Subsurface Wastewater Unit

Subject: Approval **WITH STIPULATION, (#4 & #5 BELOW)** Replacement System Variance Request, Andrew MacDonald Property, 37 Wharf Road, Portland, Maine. Mailing Address Of: Owner/Applicant: 398 Sebago Road, Hiram, Maine, 04041.

We have completed our review of an HHE-200 Form dated 10-05-2015 for the property at 37 Wharf Road, Portland, Maine.

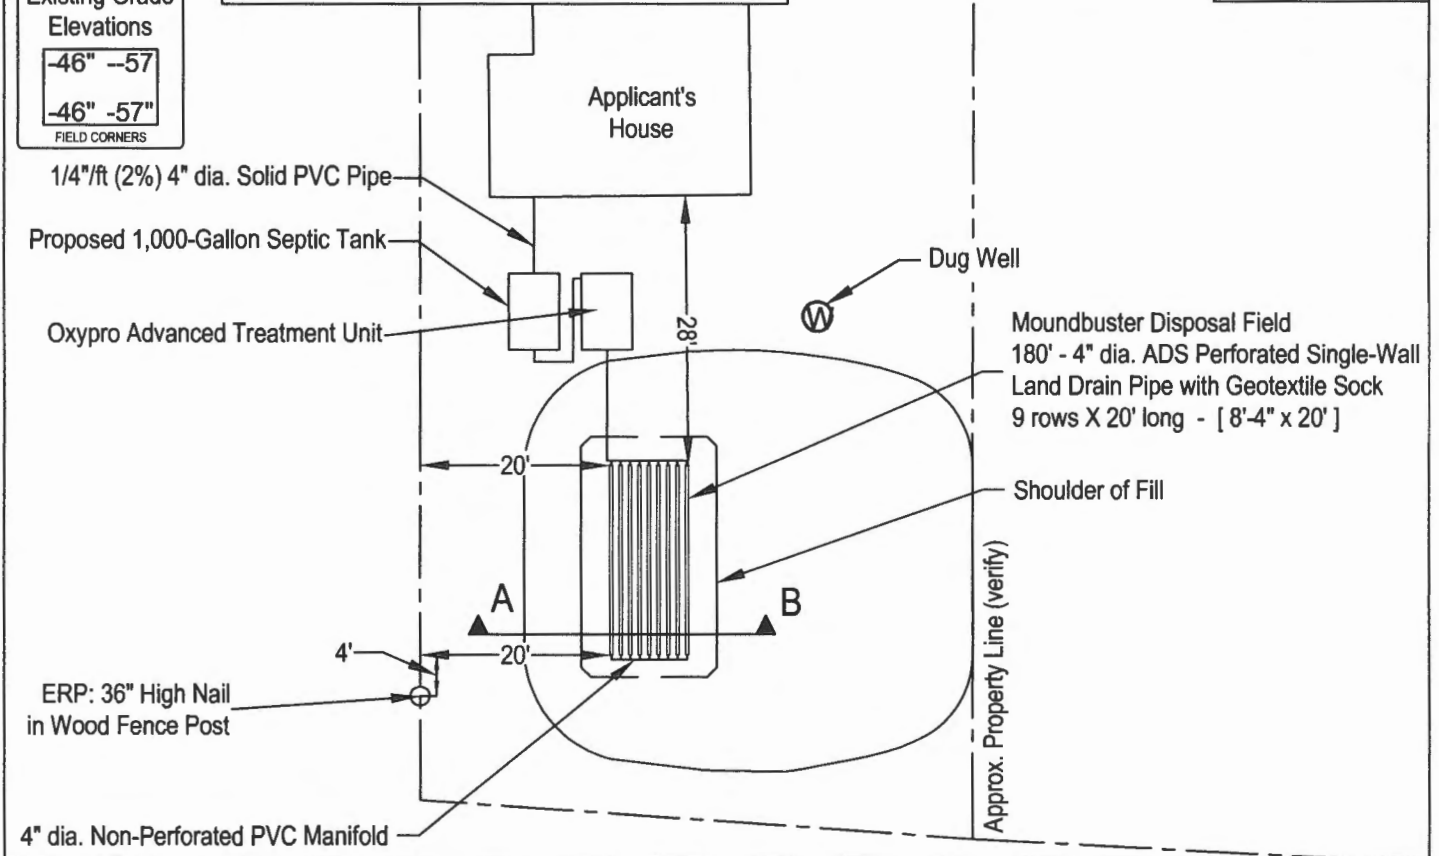
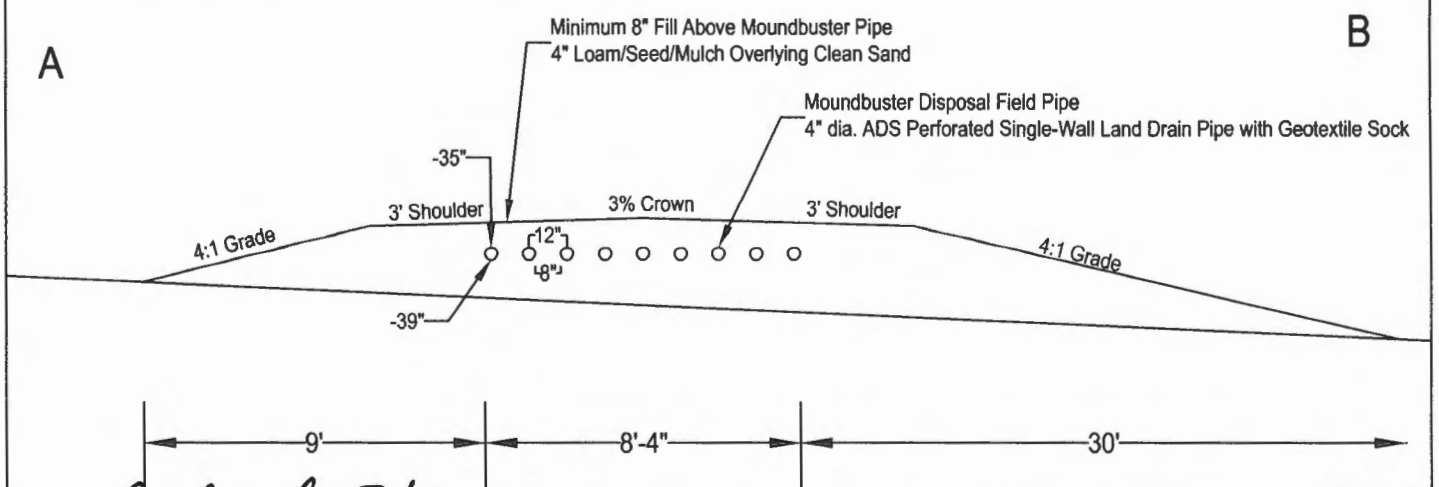
The variance requested which is not within the LPF's authority is from the disposal field to a potable water supply 21 feet and to the seasonal high water table of zero inches.

The variances requested that is within the LPF's authority is from the disposal field to potable water supplies of 67 feet, 68 feet and 80 feet. (The Public water supply, if found is not an actual Public water supply will be under the jurisdiction of the Local Plumbing Inspector for variance)

The variance request has been submitted because topography and existing development limit the potential of the system location and the system design prepared by Richard Sweet SE # 34 on 10-05-2015 is otherwise found to be in compliance with the Maine Subsurface Wastewater Disposal Rules.

4. BEFORE PERMITTING THE POTABLE WATER SUPPLY THAT IS LOCATED 21 FEET FROM THE PROPOSED DISPOSAL FIELD WILL BE RELOCATED TO A MINIMUM DISTANCE OF SIXTY FEET AND PROPERLY ABANDONED.
5. HHE-200 APPLICATION AND VARIANCE FORM MUST BE SIGNED BY THE OWNER/APPLICANT BEFORE ISSUING A PERMIT.
